**From:** Geof Mansfield <gmansfield@ncc.nsw.gov.au>  
**Sent:** Tuesday, 20 July 2021 10:27 AM  
**To:** Katelyn Symington  
**Subject:** FW: Modification 1 Additional areas and layout (SSD-7698-Mod-1)

**From:** Geof Mansfield <gmansfield@ncc.nsw.gov.au>  
**Sent:** Tuesday, 20 July 2021 10:16 AM  
**To:** Katelyn Symington <Katelyn.Symington@planning.nsw.gov.au>  
**Subject:** FW: Modification 1 Additional areas and layout (SSD-7698-Mod-1)

Further to my email of 18 July 2021 and our telephone conversation of earlier today it is confirmed the applicant's response to Items 2 - Contamination and Item 3 - Environmental Impacts has been reviewed by our Environmental Health Coordinator and the following advice has been provided:

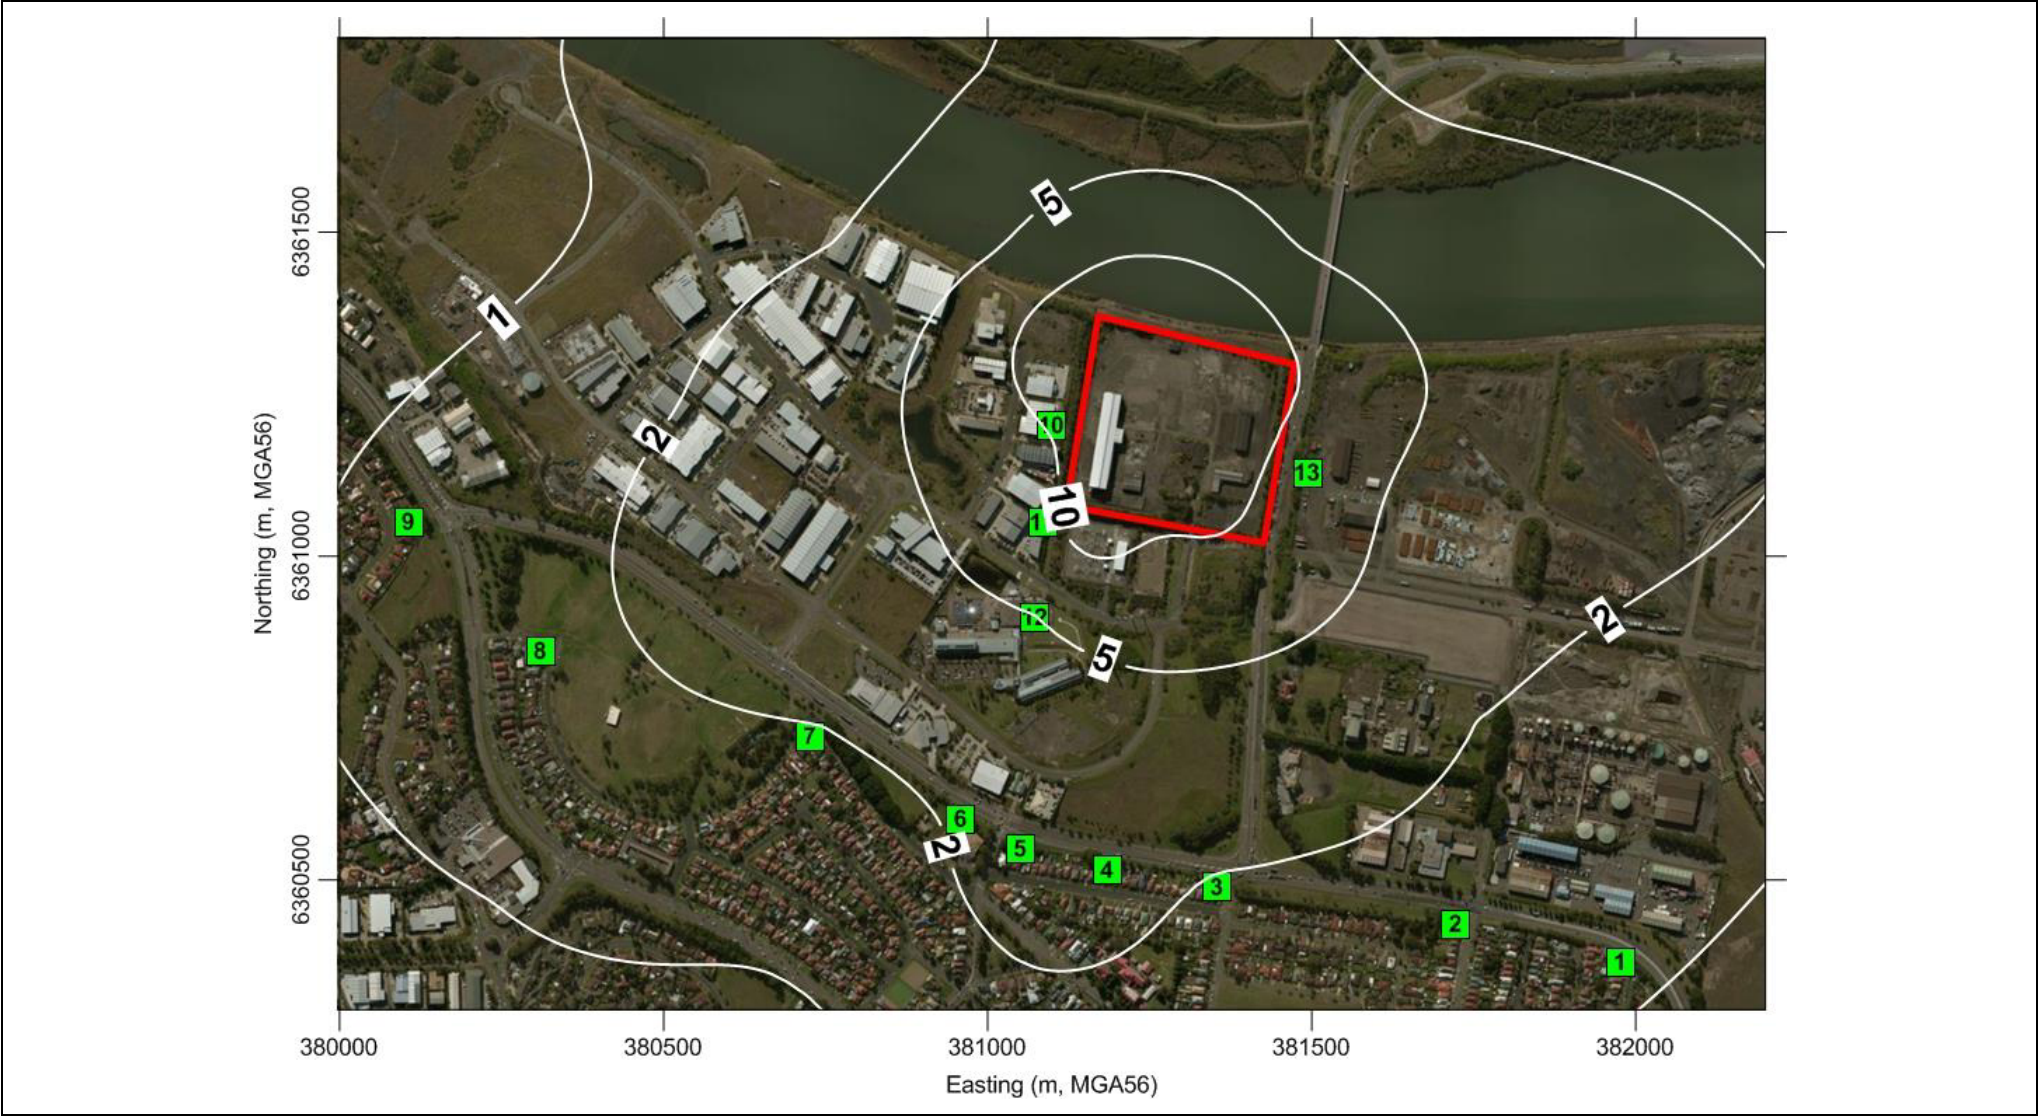
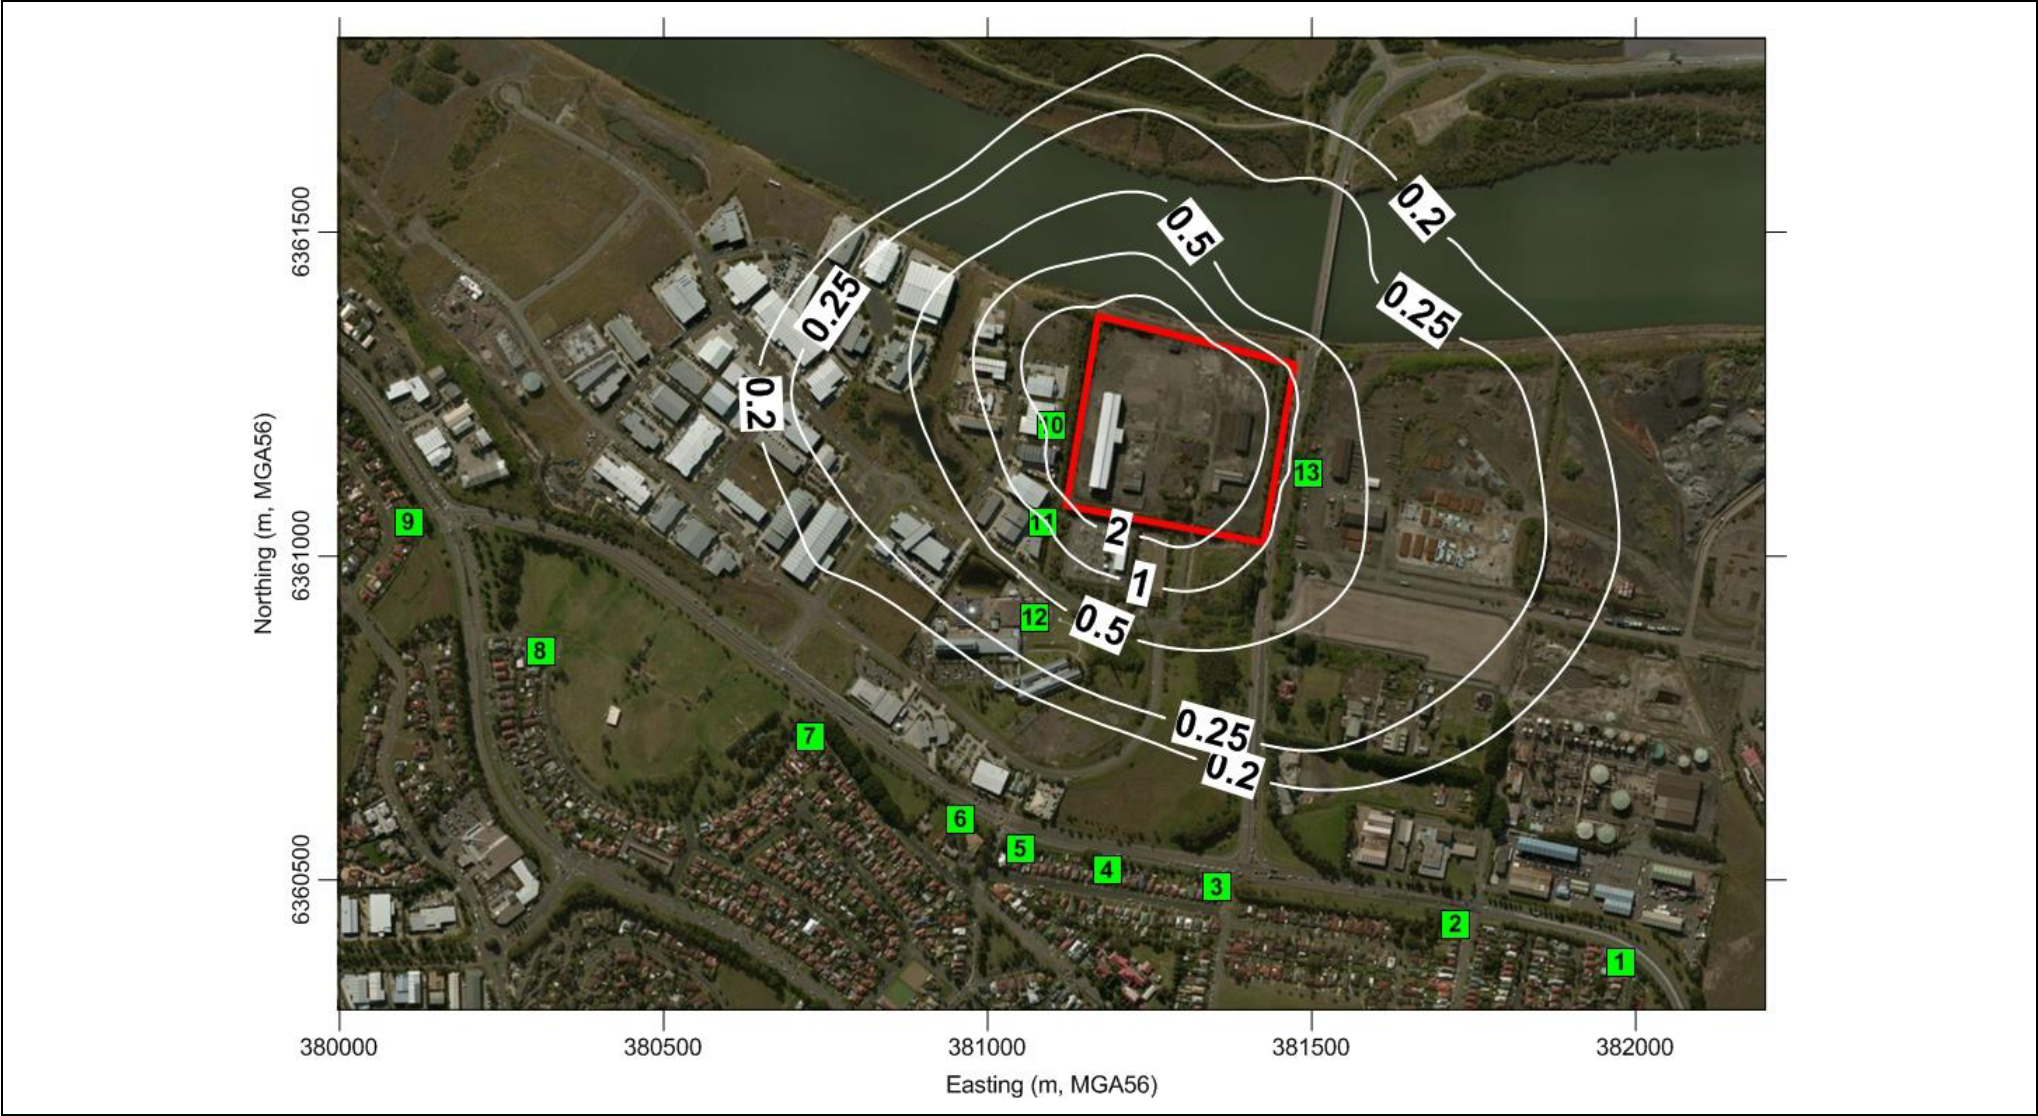
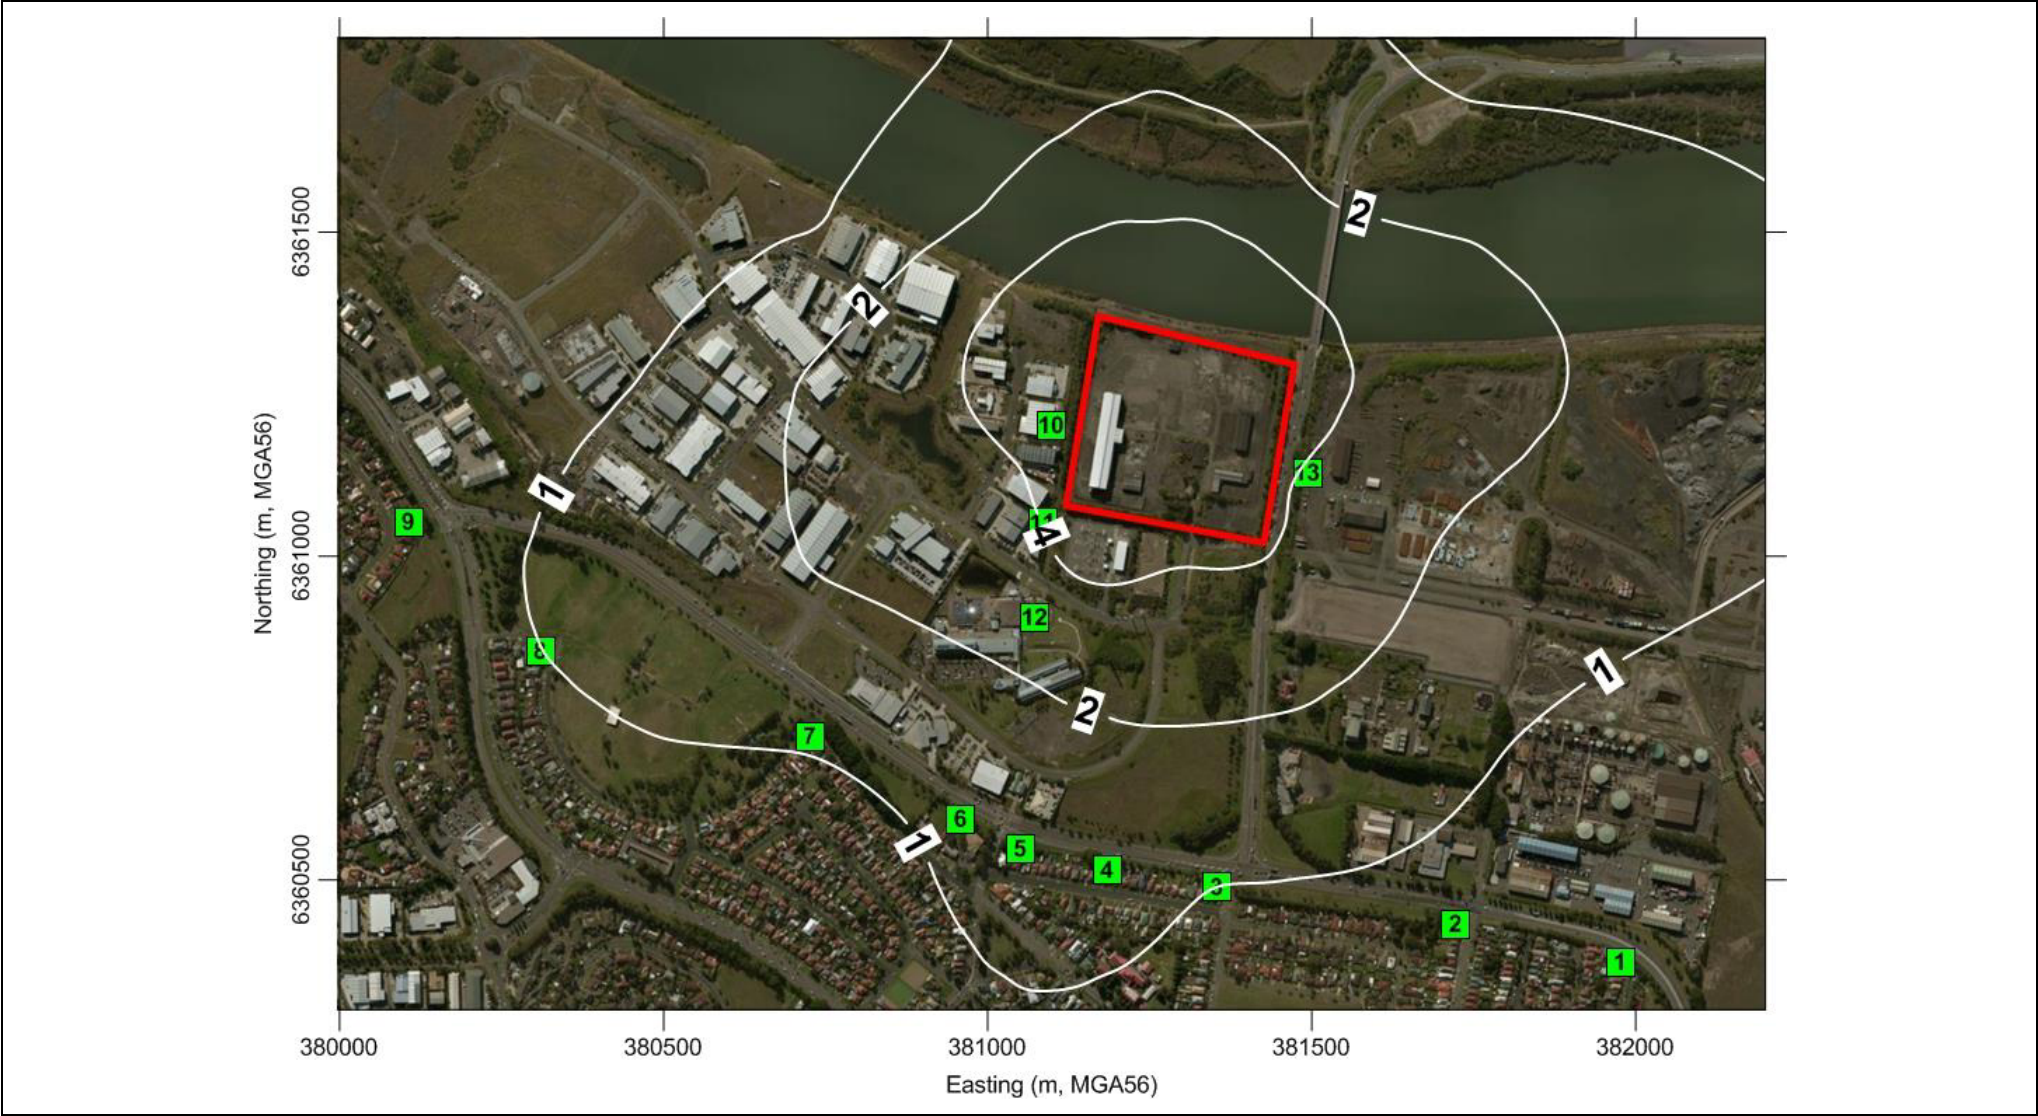
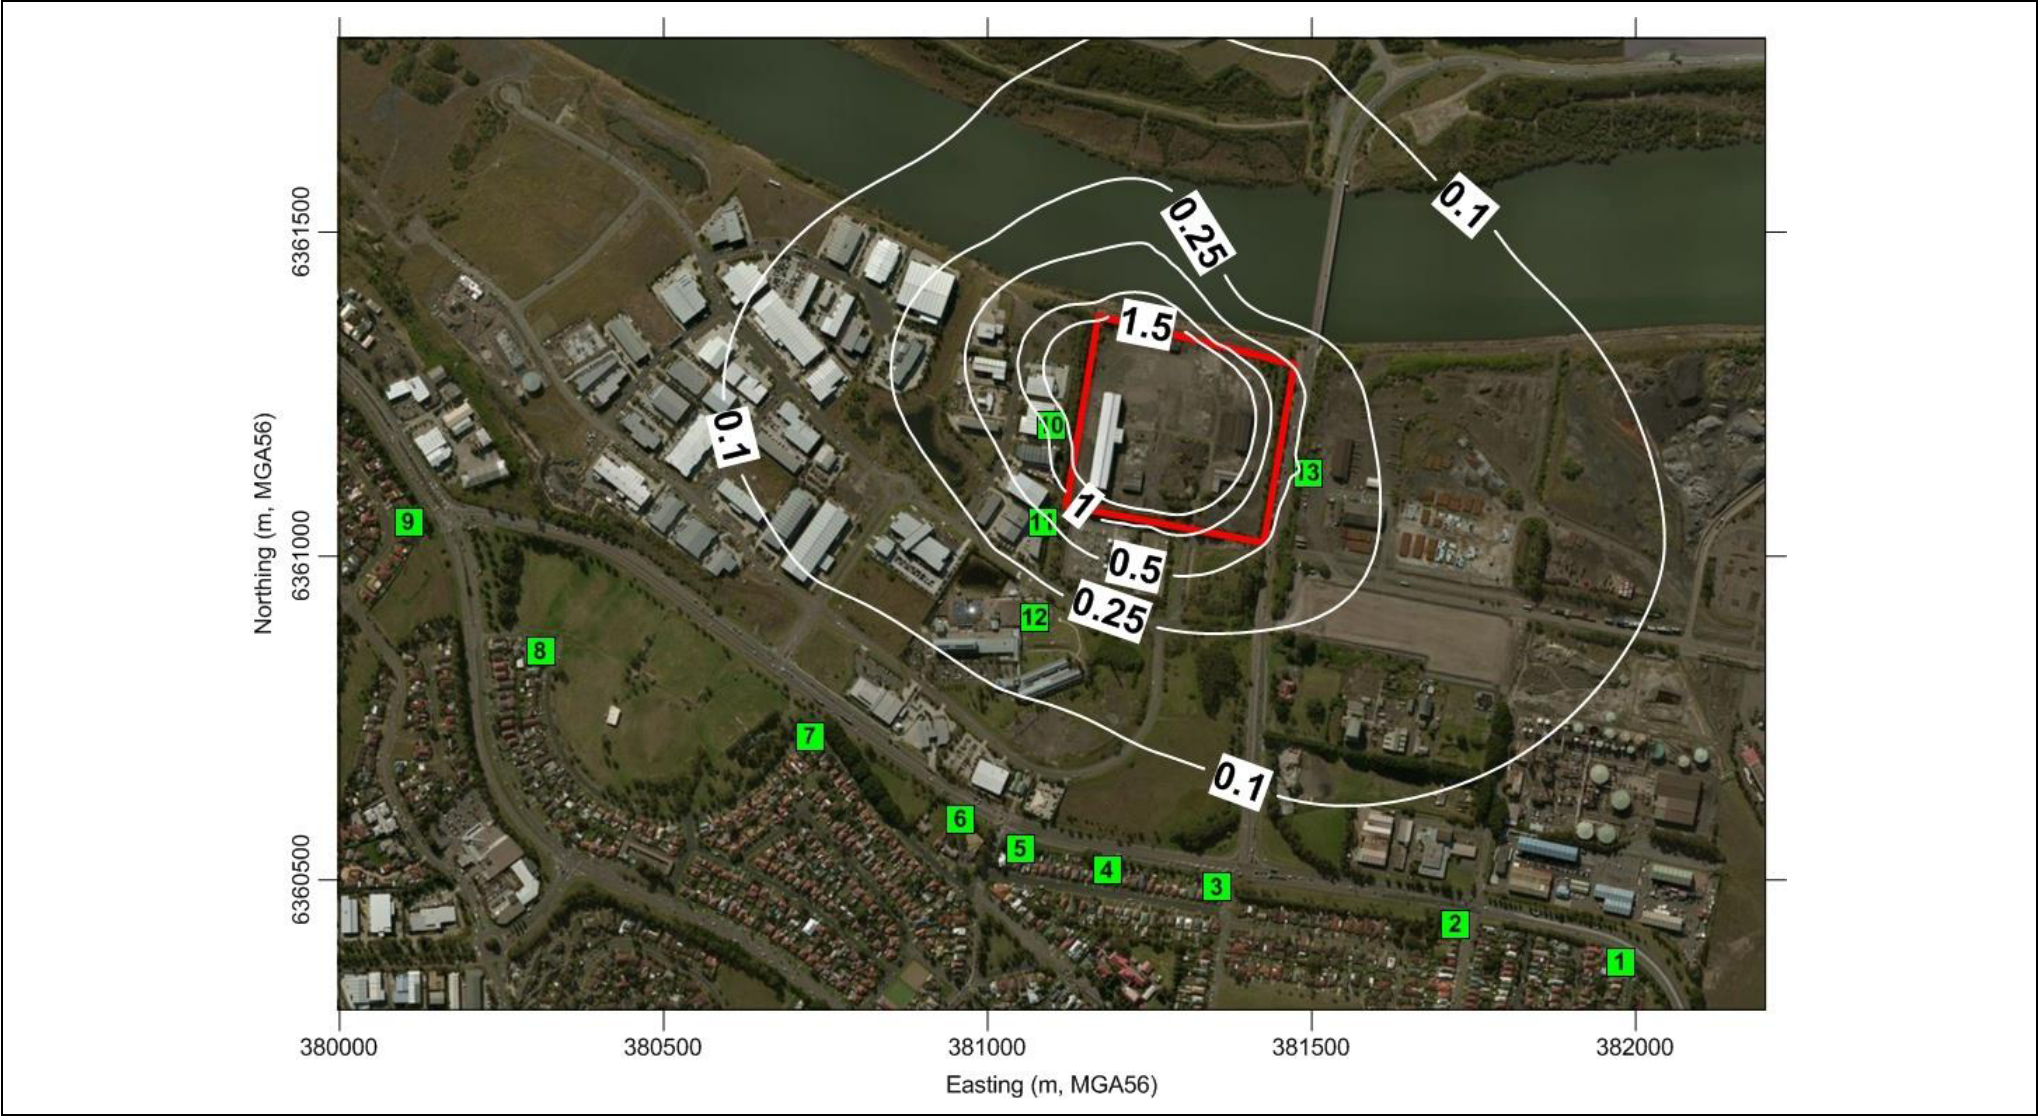
*They have considered our comments and note that there were errors in their previous documentation. They have reviewed the air quality impacts associated with the proposed increase in stockpiling area and provided revised information. This accuracy of the revised information and the significance of the predicted increase in air emissions can be reviewed and addressed by the appropriate regulatory authority (NSW EPA). '*
